WESTMEAD CATHOLIC COMMUNITY EDUCATION CAMPUS APPENDIX A - RESPONSE TO SUBMISSIONS AND REQUEST FOR ADDITIONAL INFORMATION AND CLARIFICATIONS

LANDSCAPE ROOFTOP SOIL DEPTHS- LEVEL 5

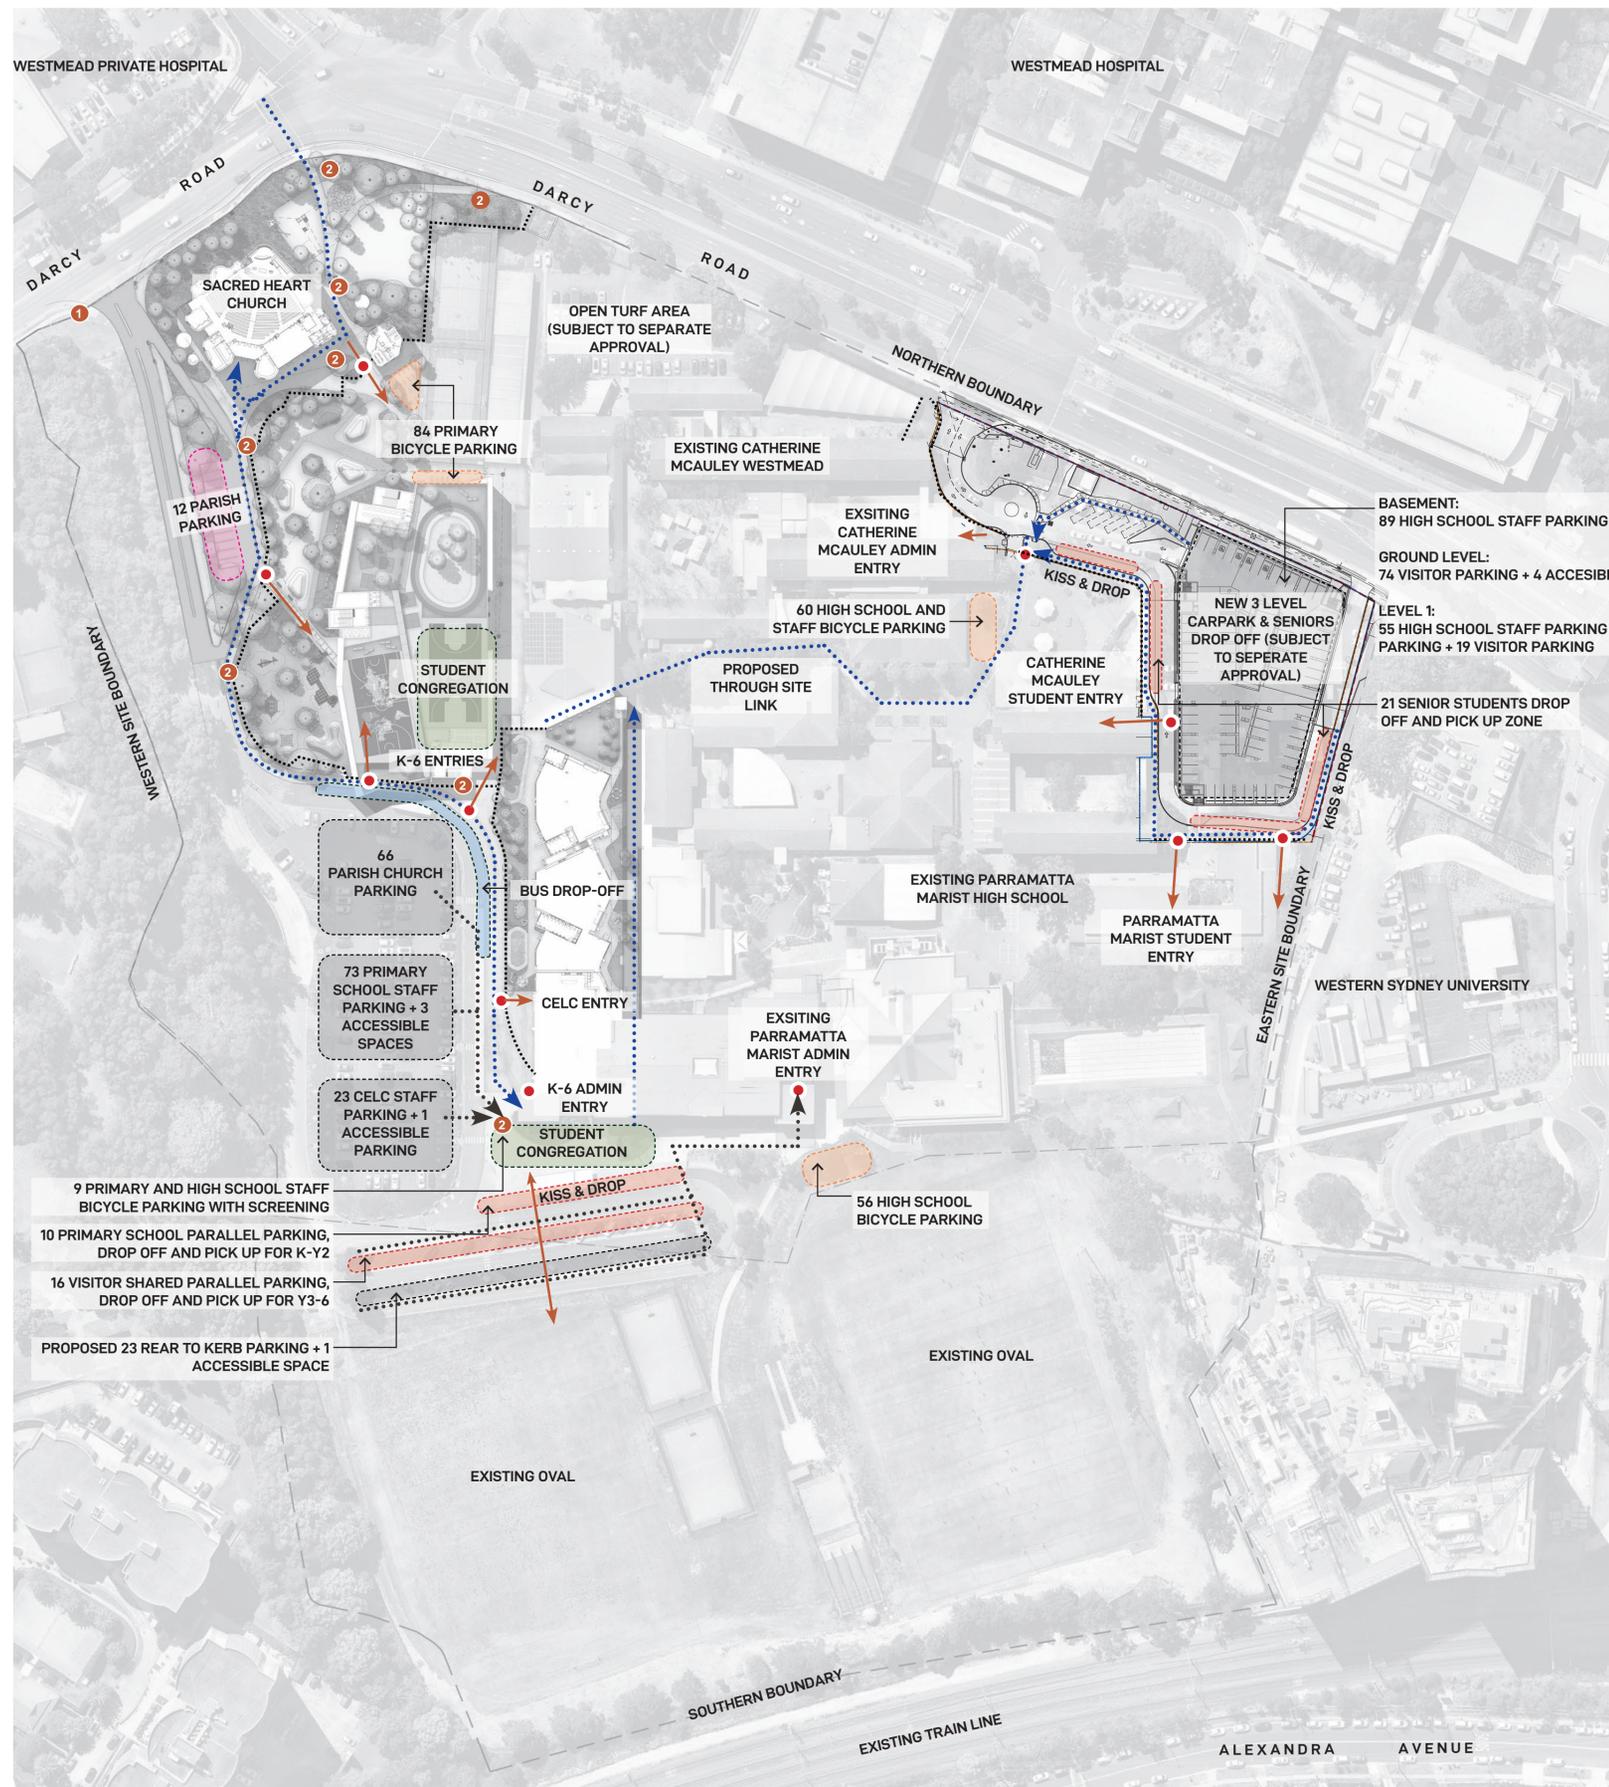
24			<p>A plan of deep soil planting is to be provided to demonstrate the proposed planting within the levels of the primary school building would be feasible.</p>	<p>Ground Ink has prepared a plan to show soil depths at Level 5 (roof level) of the proposed building (refer to Appendix F).</p>

Item No	Name	Type	Issue	Response
25			A detailed calculation of the proposed tree canopy on the site must be submitted for assessment.	<p>The plan shows several areas of deep soil planting at roof level, which have soil depths of up to 1,500mm. These areas will be capable of accommodating tree planting, including large shade trees.</p> <p>A Tree Canopy Coverage Plan has been prepared by Ground Ink and is included at Appendix F.</p> <p>The Plan shows that within the site of the proposed works, there will be a total tree canopy coverage of 4,685m² (4,508m² proposed and 207m² existing). This equates to 25% of the development site area and balances the need to provide adequate tree coverage, whilst also providing a safe and usable outdoor space for students and the community.</p>
26			<p><u>Wind Impact Assessment</u> A wind impact assessment including human and pedestrian comfort criteria for the proposed development is to be submitted. The wind assessment should include consideration of the rooftop play areas.</p>	<p>The submitted Wind Assessment has been updated to address the Department's comments (refer to Appendix H).</p> <p>With respect to conditions at roof level, the pedestrian comfort category under the Lawson criteria is likely to be pedestrian standing or walking. At this elevation, parts of the space will be reasonably exposed to strong prevailing winds from most directions. Depending on the wind direction, calmer conditions would be available in locations protected by the stair and plant wall structures. The central area under the shade structure is partially enclosed by louvres and the plant room, and relatively calm conditions would be expected there. This area would be most suited for longer-term stationary occupation.</p> <p>In general, the following measures may be considered if a calmer wind environment more suited to stationary activity, seating, dining, and the like is required for the rooftop:</p> <ul style="list-style-type: none"> • Addition of landscaped areas incorporating dense foliage - in addition to the larger trees indicated, lower-level planting such as shrubs and hedges may be effective in mitigating strong winds. This may be effective at the building perimeter and/or distribute across the space. • Screening elements, similar to the louvred screens proposed elsewhere or solid screens, to seating areas. • High (>1.5 m) perimeter balustrades. An effective approach may consider a mix of solid balustrade and porous media such as landscaping or porous screening at the roof edges. <p>As the required mitigation depends on the intended use of the space and desired wind environment, these measures are not considered prescriptive, but rather guidance for improving conditions as required.</p> <p>As the roof top space is intended for active play rather than stationary activities, CEDP does not intend on implementing any of these measures at this stage.</p>
